Council Reference: DA09/0701.03 LN35979
Your Reference:

Development Application DA09/0701.03 - amendment to Development Consent DA09/0701 for a 251 lot residential subdivision (Department of Planning Application MP09_0166 MOD 3) at Lot 1 DP 169490, Lot 1 DP 175235, Lot 1 DP 304649, Lot 1 DP 781687, Lot 1 DP 781697, and Lots 40 & 43 DP 254416: No. 37 Fraser Drive TERRANORA; Lot 2 DP 778727: Parkes Lane TERRANORA

I refer to your email of 6 August 2019 in which you notify Tweed Shire Council of the Proponents' Response to Submissions regarding the subject Modification.

NEWLAND DEVELOPERS PTY LTD	09-374 03-07-2013
TERRANORA PRECINCT 1 ROAD HIERARCHY PLAN	SK3628 REVISION E

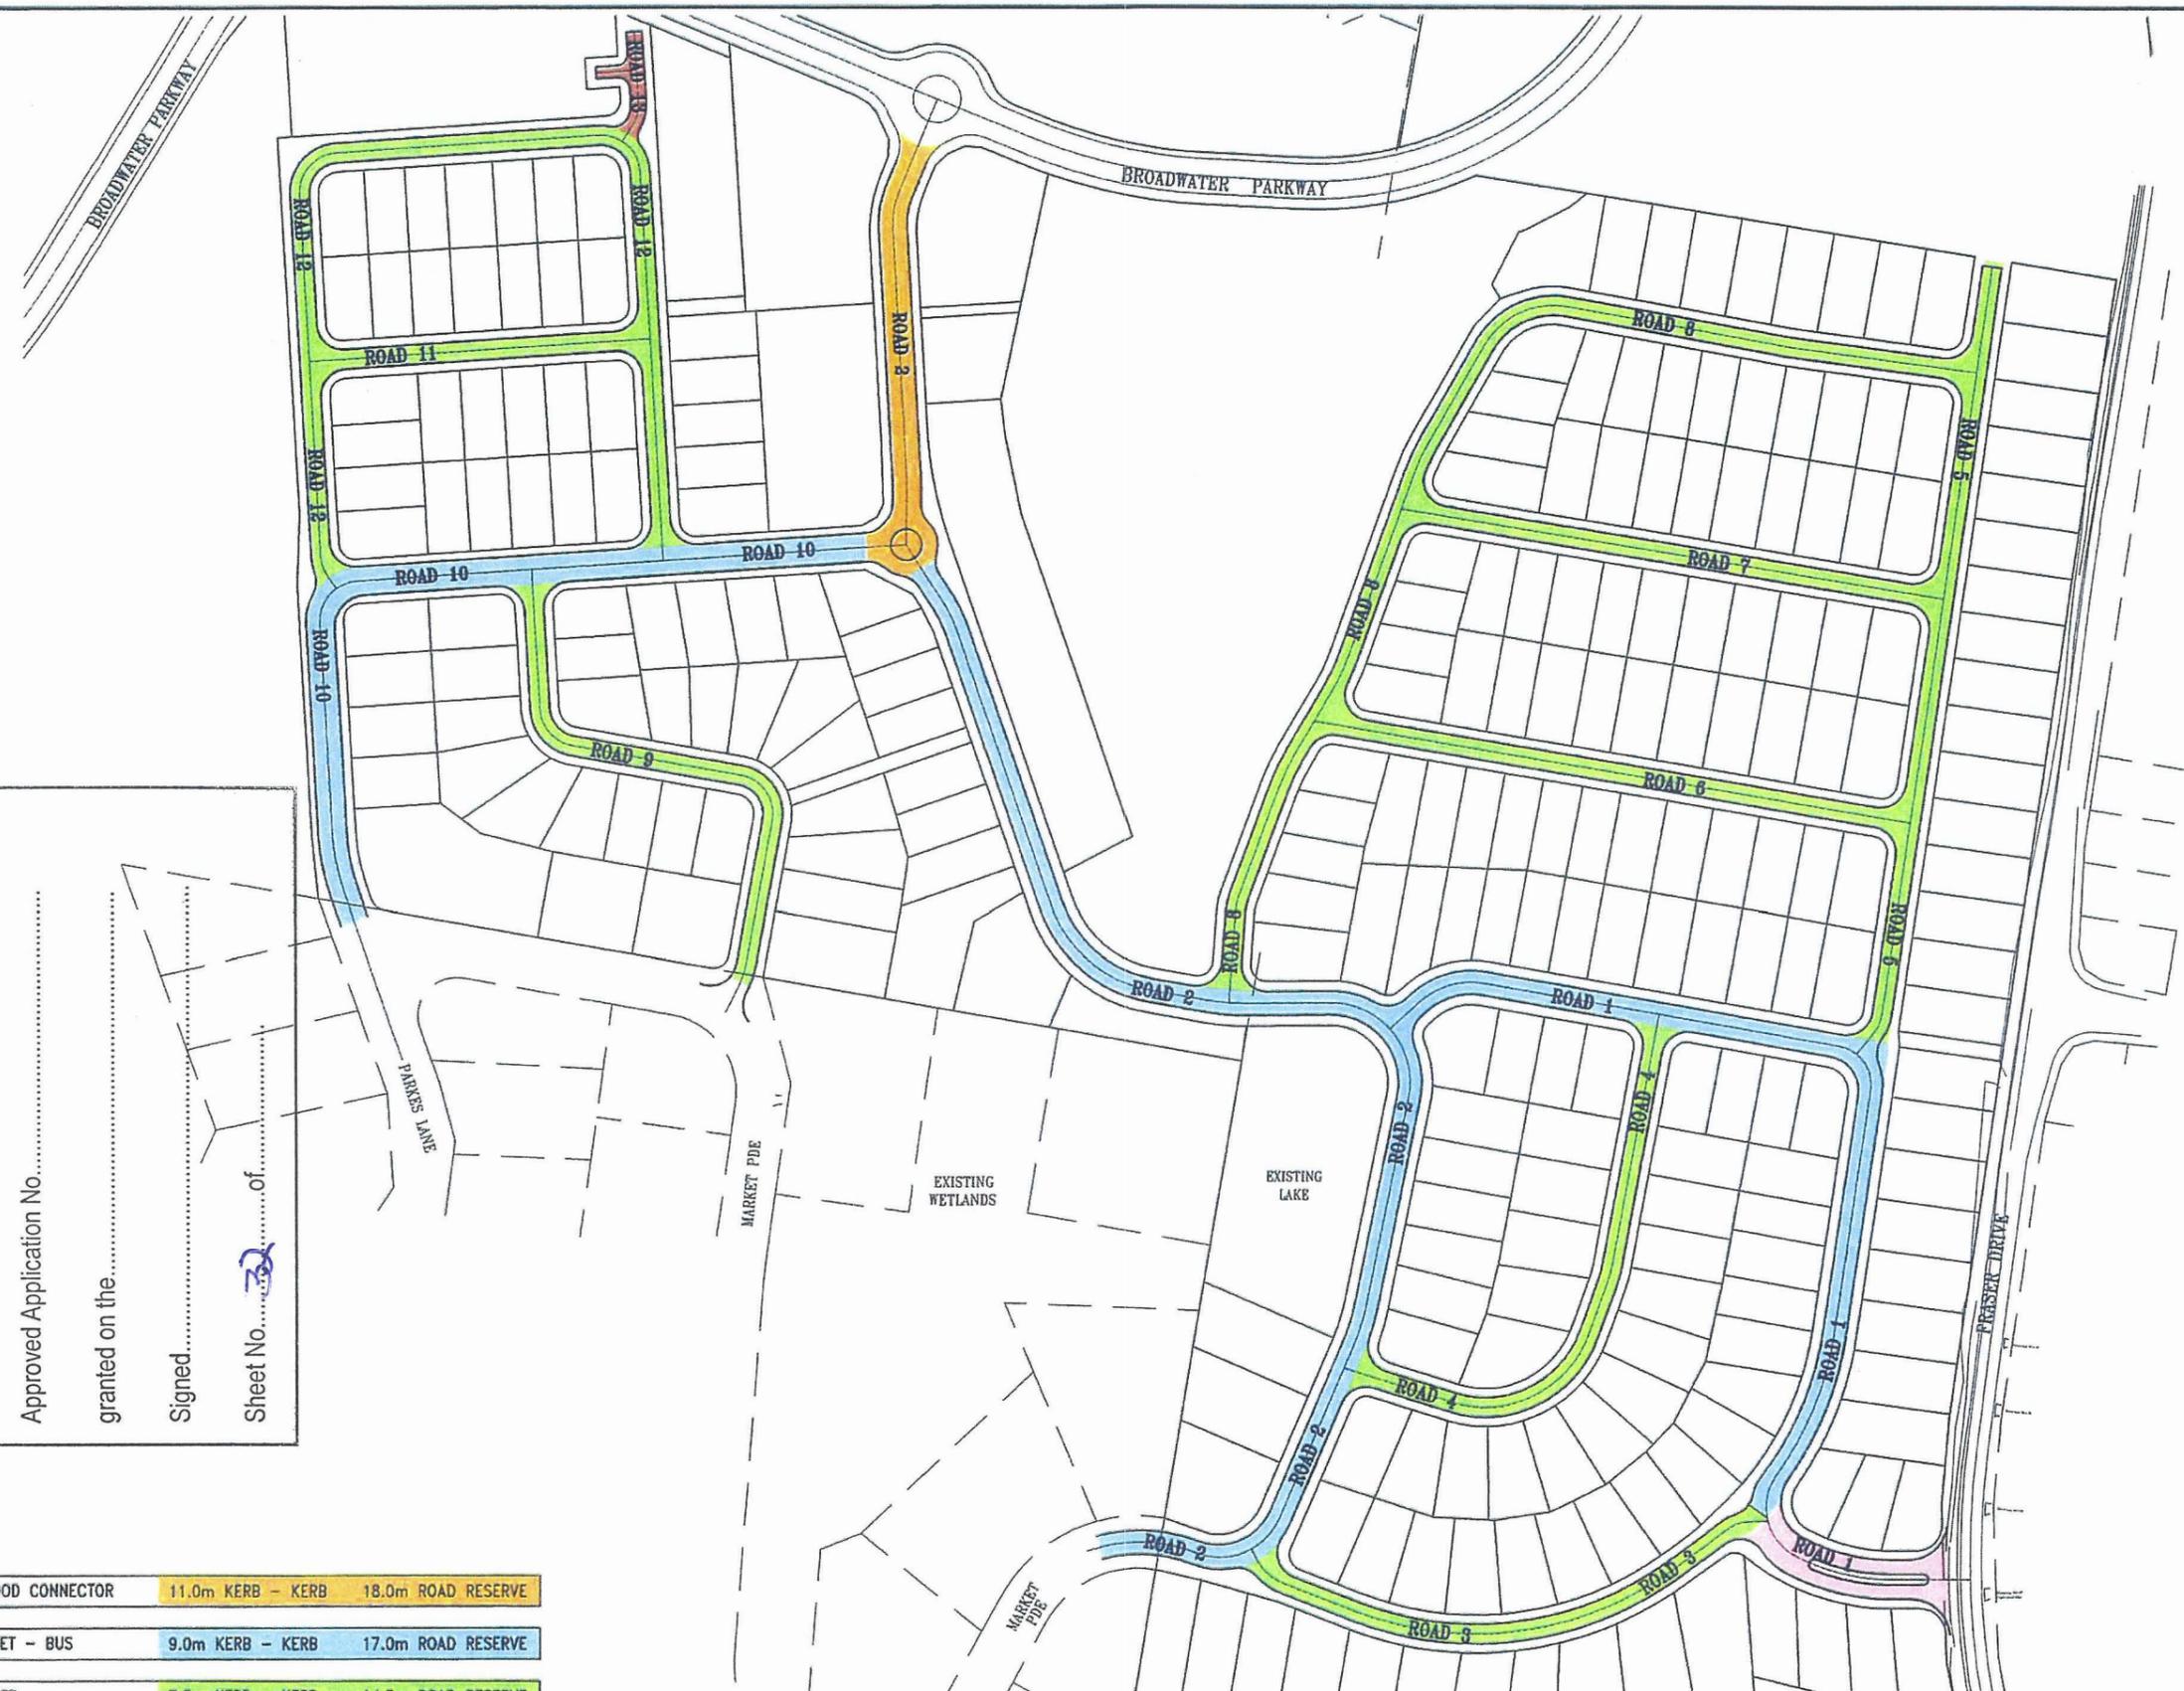
- SK 3608 is the longitudinal section for Road 9, and has been satisfactorily amended to accord with DA Condition B10, however no other associated plans have been changed to reflect Road 9 becoming a cul-de-sac – eg: the separate list of 'Local Office Architecture' plans; engineering plans for 'Road Hierarchy', stormwater, sewer and water provisioning.
- While the Surveyor's subdivision layout plans have been amended to reflect this road change, the supporting engineering drawings were not correspondingly changed. This occurred as part of MOD #2 so will not be further pursued (now).
- It is not considered necessary to amend all other engineering drawings that show Road 9 as a 'through road', provided Condition B10 is retained.
